WEST SUSSEX COUNTY COUNCIL CONSULTATION

TO:	Arun District Council FAO: Jonny Cooper
FROM:	WSCC – Highways Authority
DATE:	2 February 2026
LOCATION:	136 Hawthorn Road Bognor Regis PO21 2BL
SUBJECT:	BR/222/25/HH Hard standing and new 3.4m vehicle crossover.
DATE OF SITE VISIT:	n/a
RECOMMENDATION:	Advice

136 Hawthorn Road - Block Plan

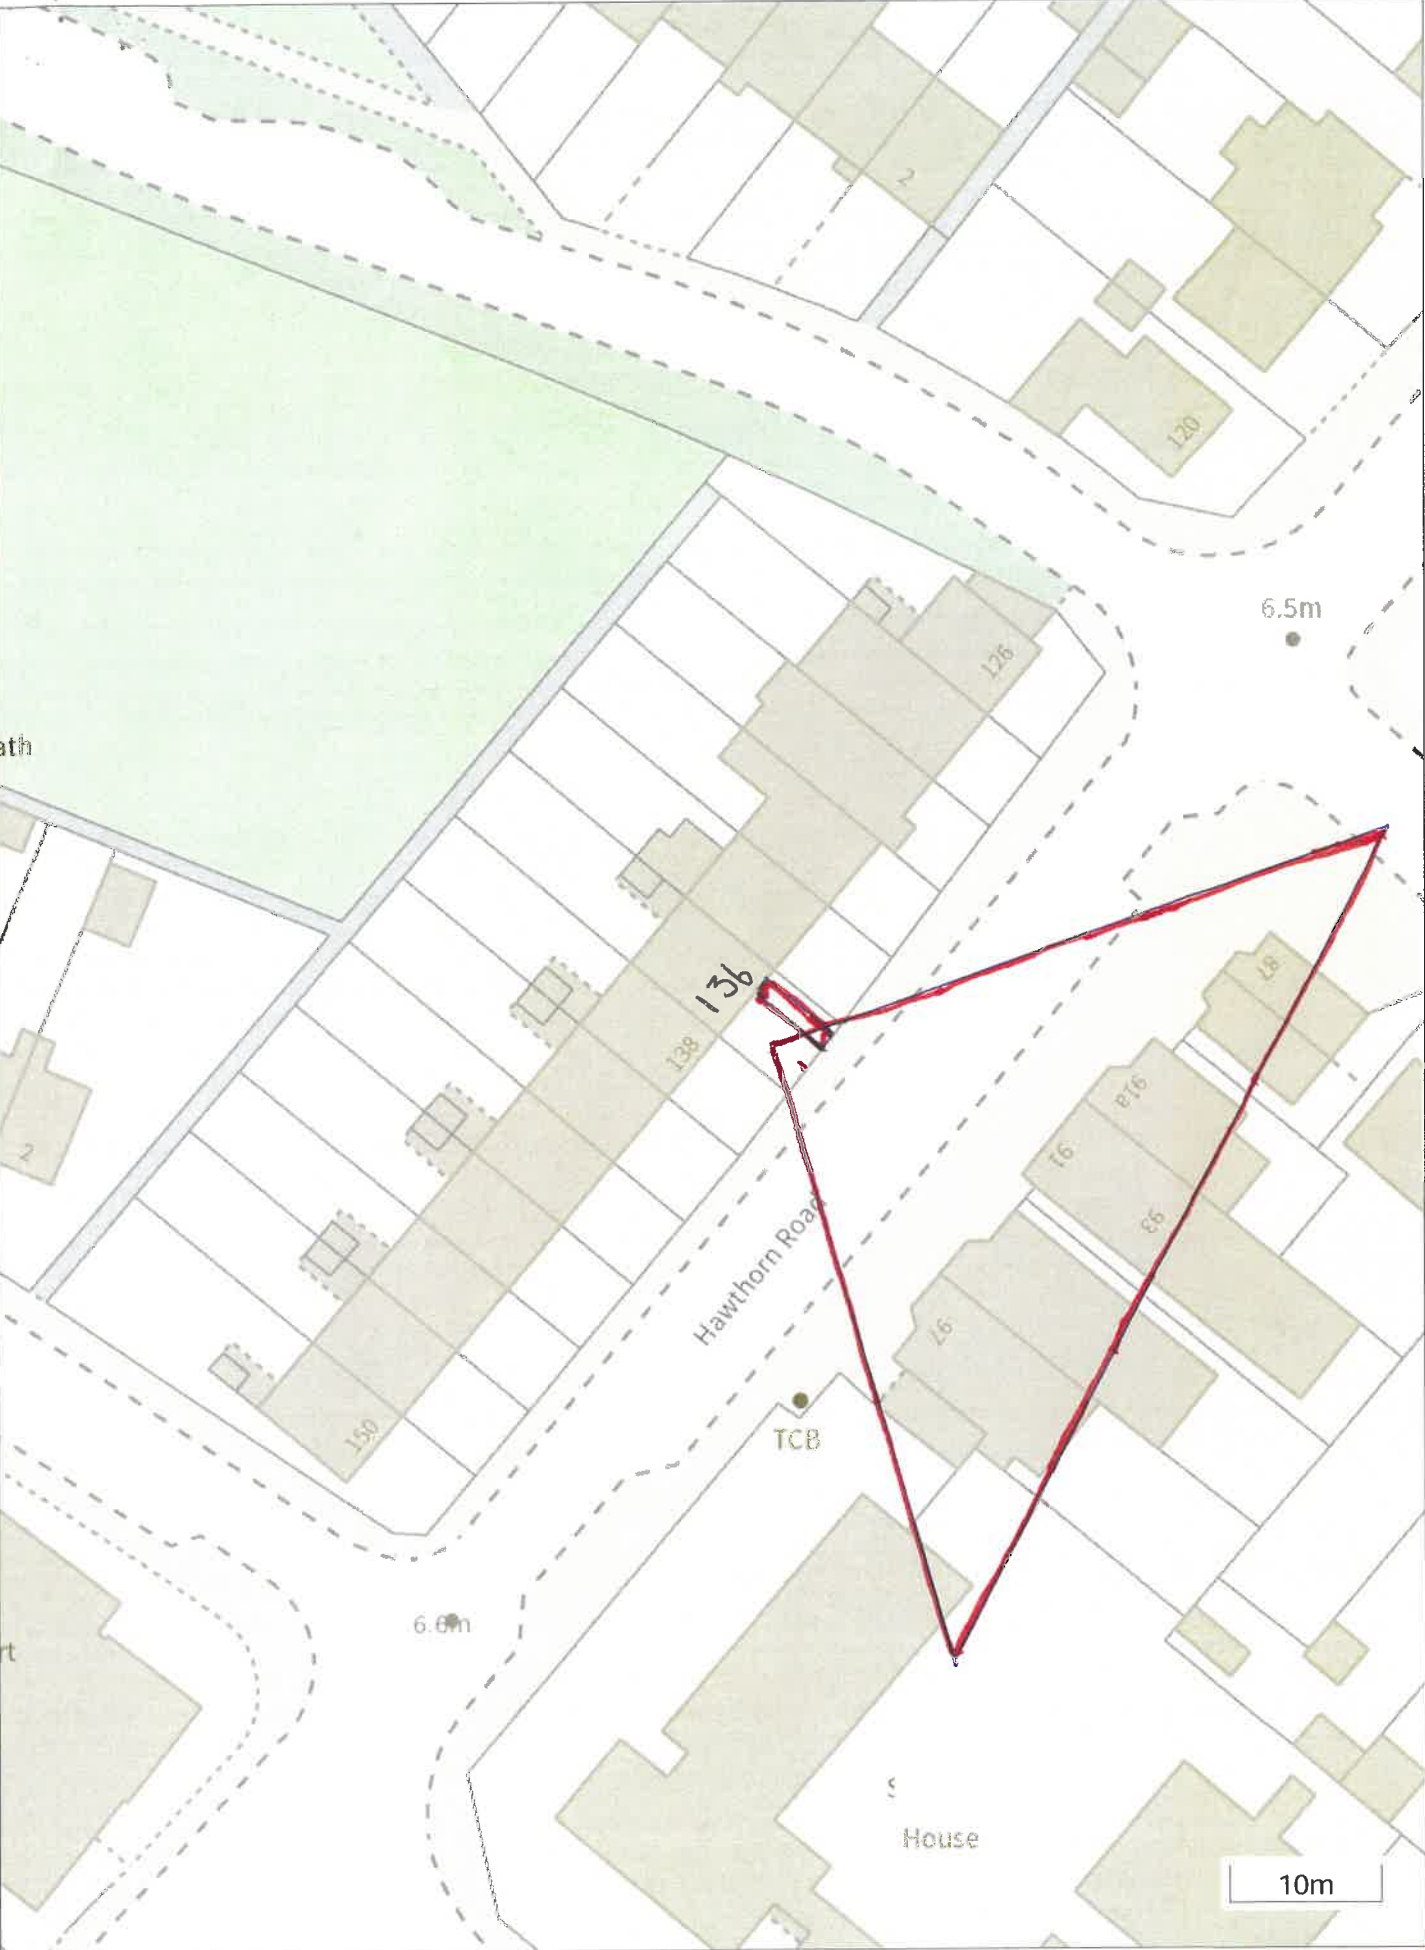
From inspection of the plans, the proposed hardstanding appears suitably sized to accommodate one off-street car parking space. A minimum of 2.4m x 4.8m is required to adequately contain an average sized vehicle. On-site turning is not achievable; therefore, a car will have to reverse either into or out of the site – however, this is not anticipated to give rise to a highway safety concern in this location, owing to the low-speed limit and good forward visibility for vehicles travelling along Hawthorn Road. The applicant should refrain from placing/planting items at the back edge of the footway in this location, which could restrict visibility of road users along Hawthorne Road.
